TRANSPORTATION DEVELOPMENT

DRB Project Number: 2023-008325  
2026 Central SW

SUBJECT: Sketch

DATE: March 15, 2023

OVERALL  
SITE PLAN

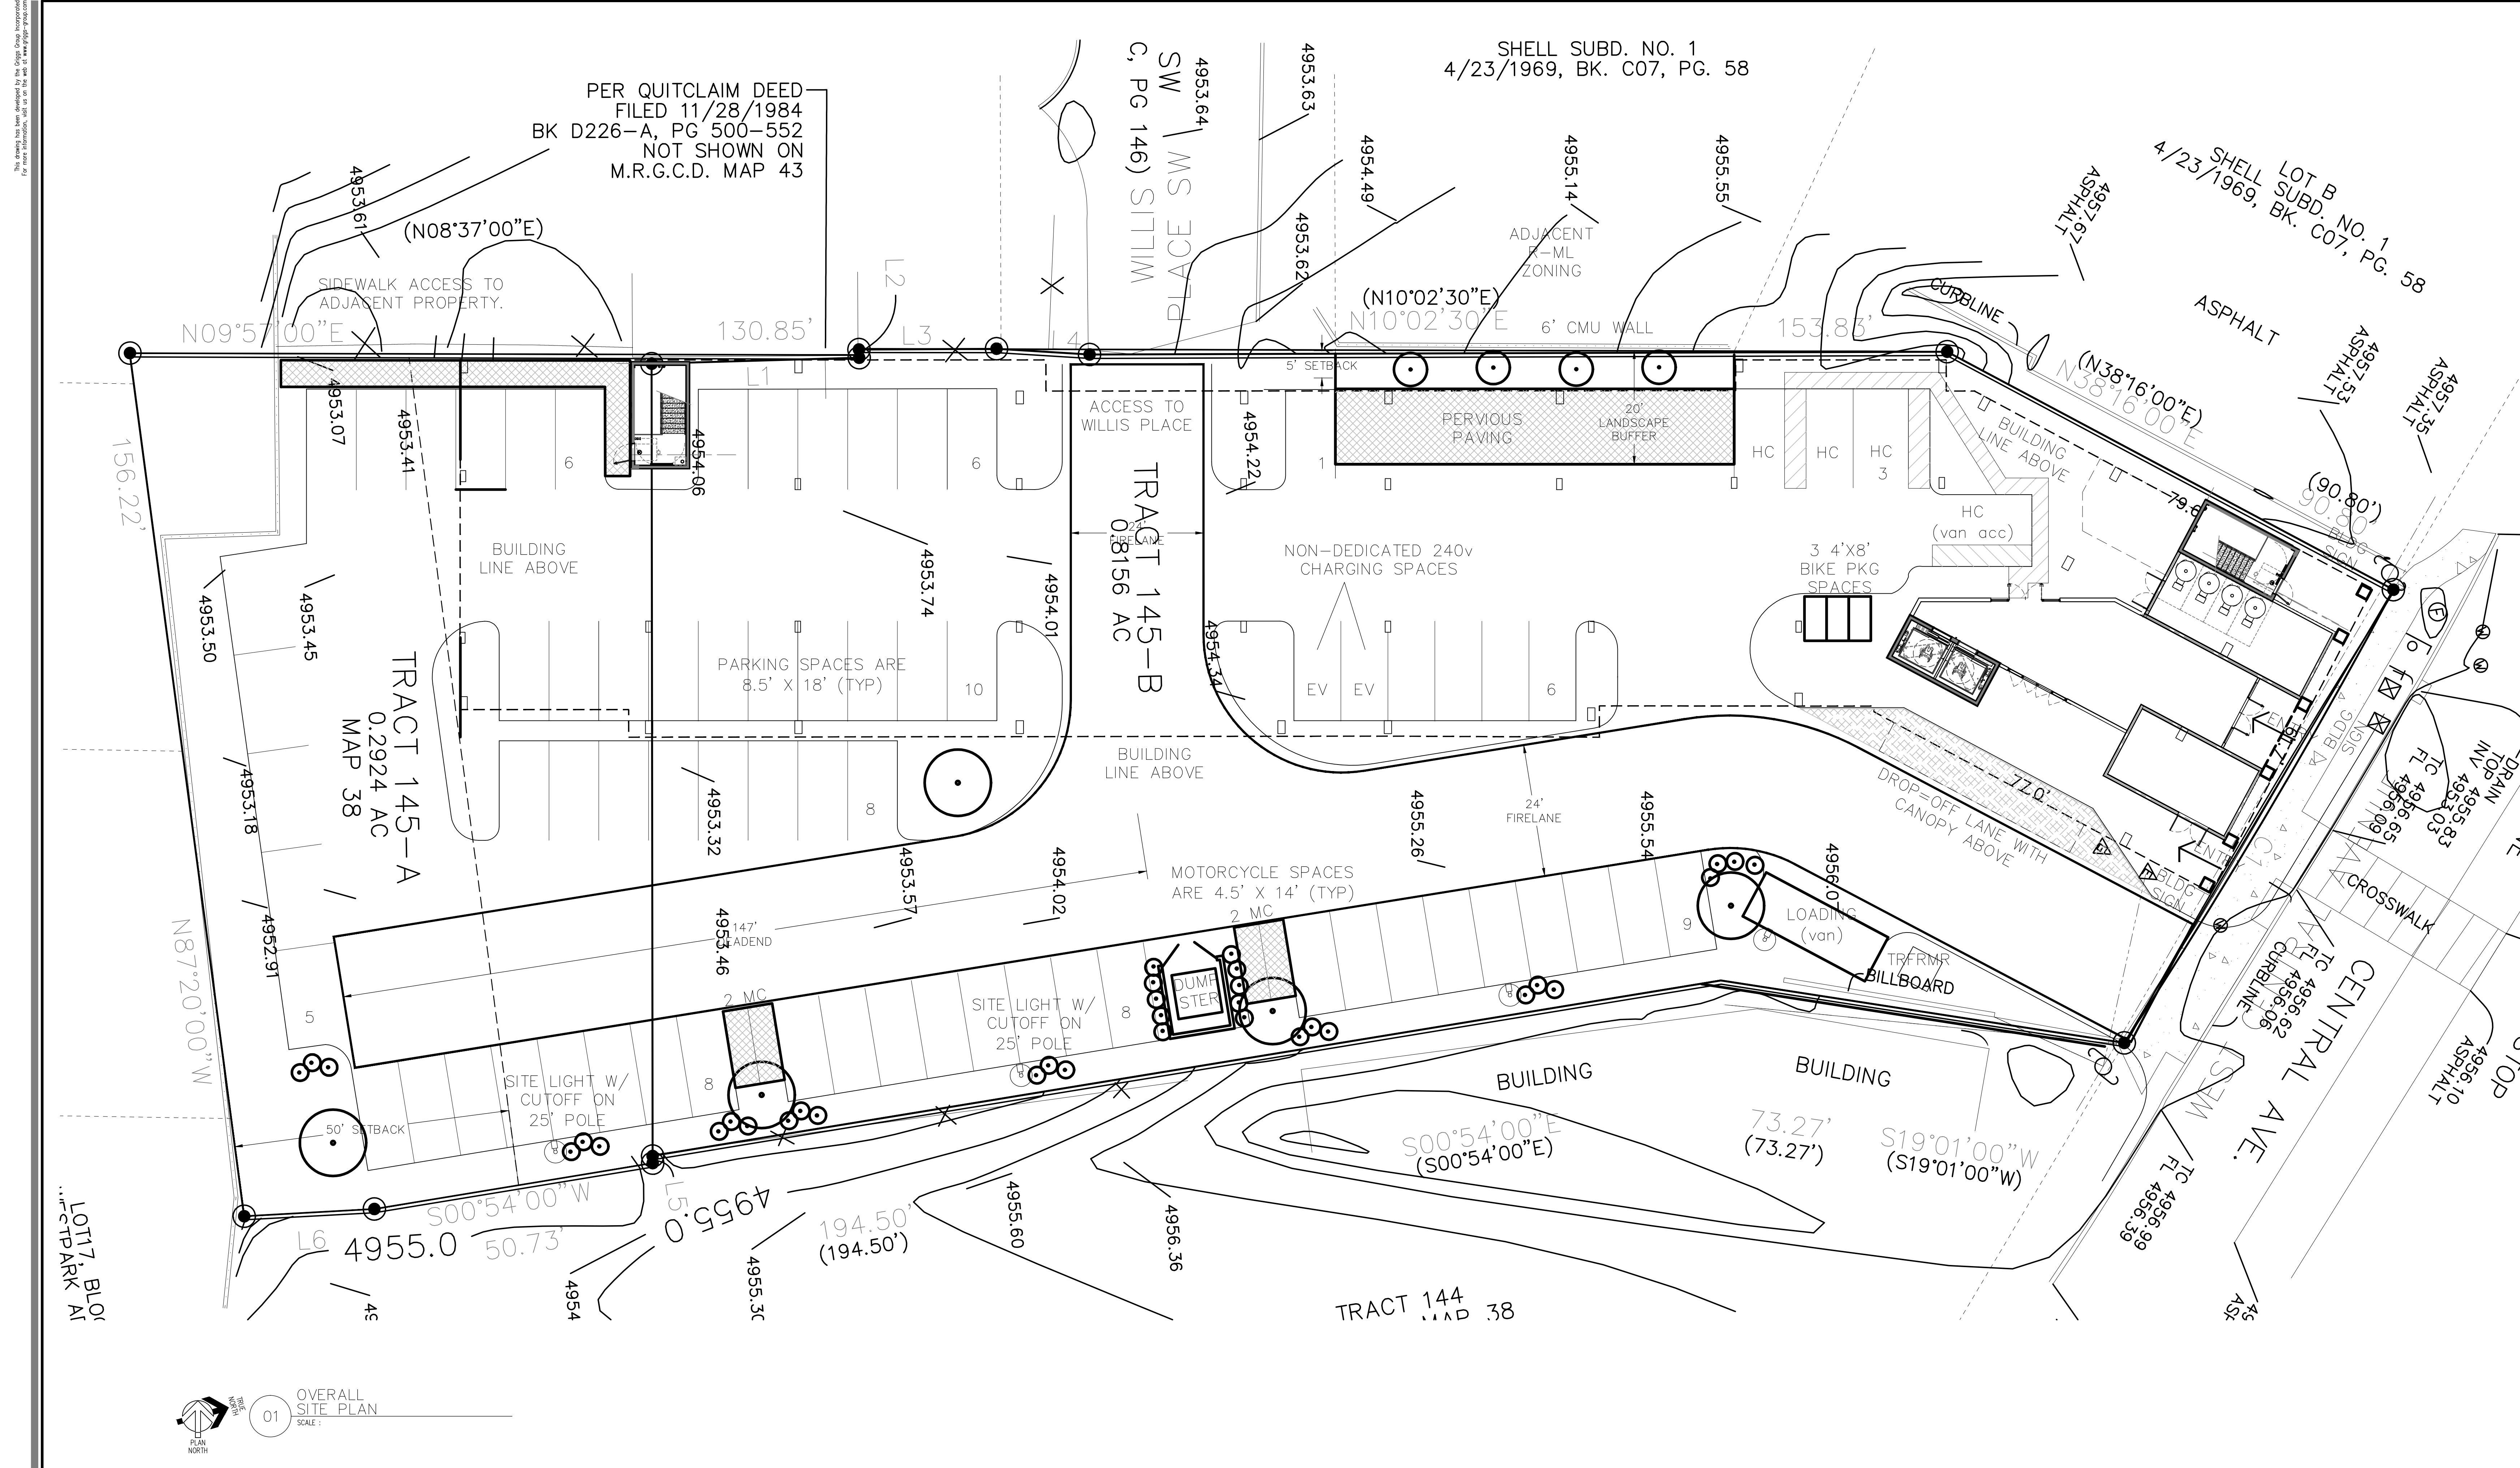
1. Please provide diagram showing existing sidewalk widths. Central is a Principal Arterial within a Premium Transit Corridor and requires 8-10' sidewalk and a 6-8' Landscape buffer.
2. An approved TCL will be required prior to site plan.
3. Please fill out and submit a Traffic Scoping Form to Matt Grush [mgrush@cabq.gov](mailto:mgrush@cabq.gov) to determine if a TIS is required.
